Mountain View Electric Association, Inc. (MVEA) has these comments about the following:

**Project Name: Cordero Minor Subdivision**

**Project Number: MS 171**

MINOR SUBDIVISION
CORDERO MINOR SUBDIVISION
A PORTION OF THE NORTHEAST QUARTER OF SECTION 1,
TOWNSHIP 14 SOUTH, RANGE 63 WEST OF THE 6TH P.M.,
EL PASO COUNTY, COLORADO

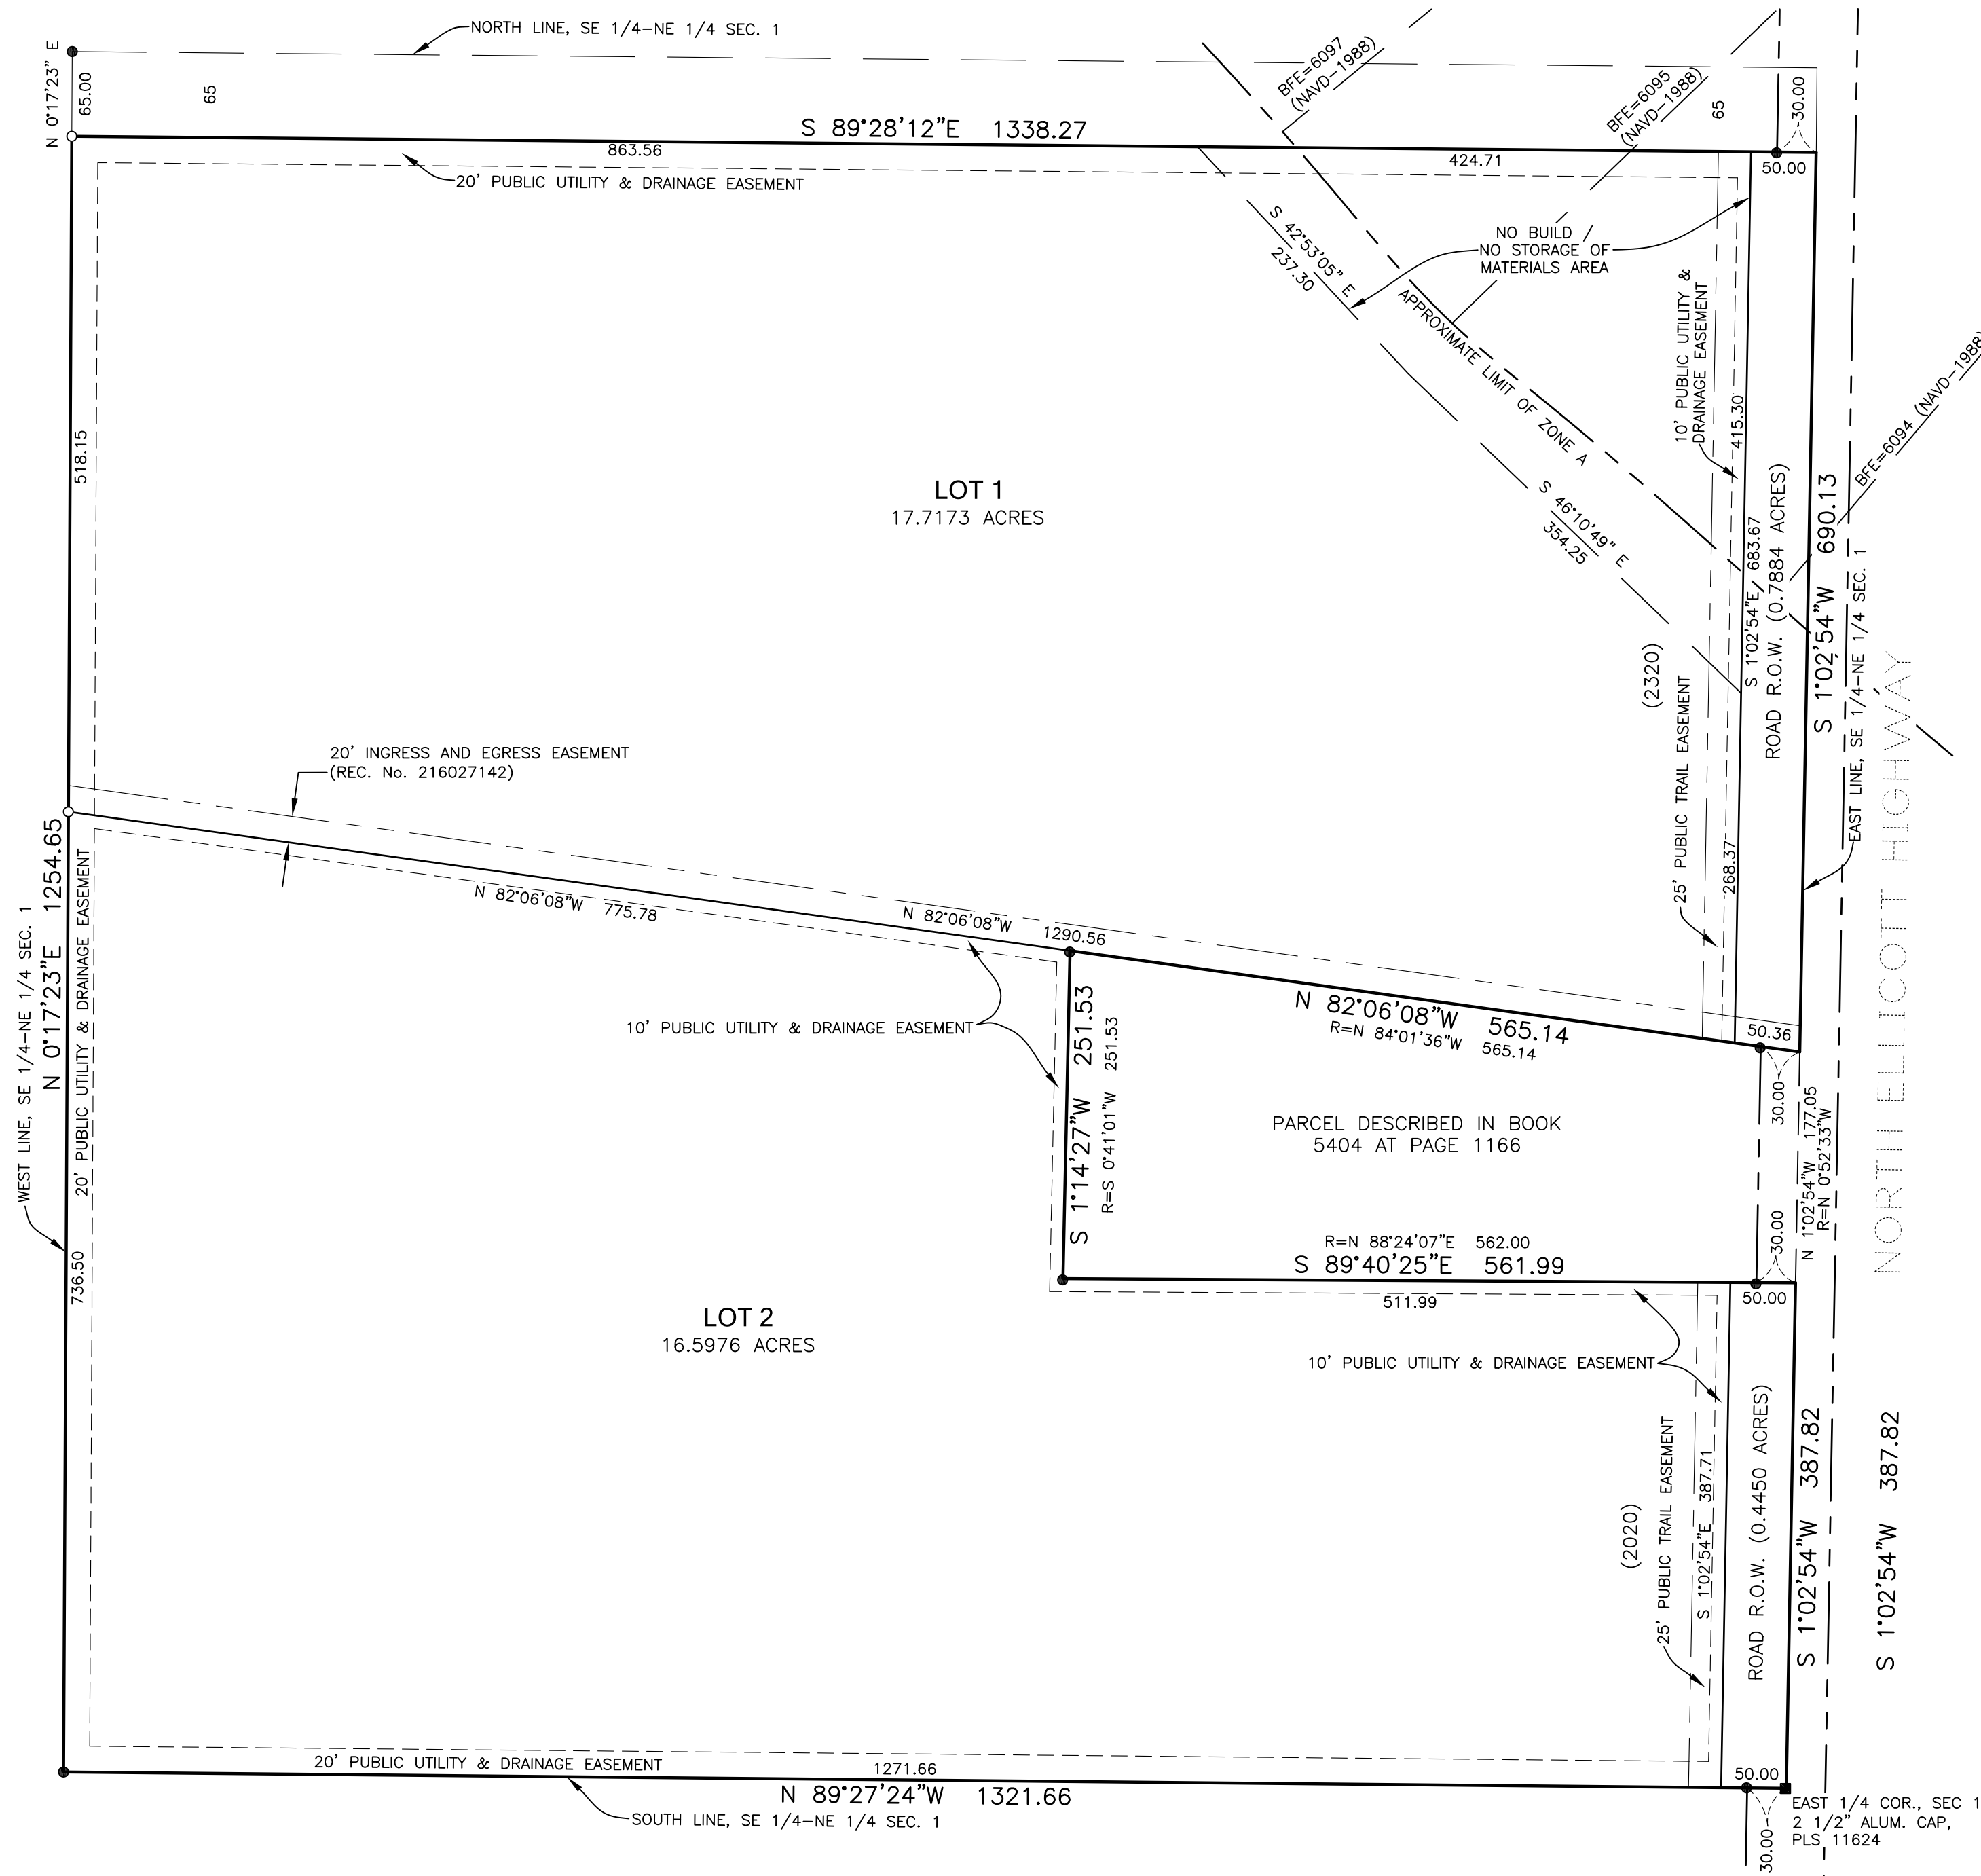
MVEA notes the utility easements of ten (10) foot side lot line utility easement along with a twenty (20) foot exterior easement on plat. MVEA also requests platting of existing MVEA facilities with easement on the plat to adjoining parcels.

MVEA has existing facilities near and within this parcel of land. If there is any removal or relocation of facilities it will be at the expense of the applicant.
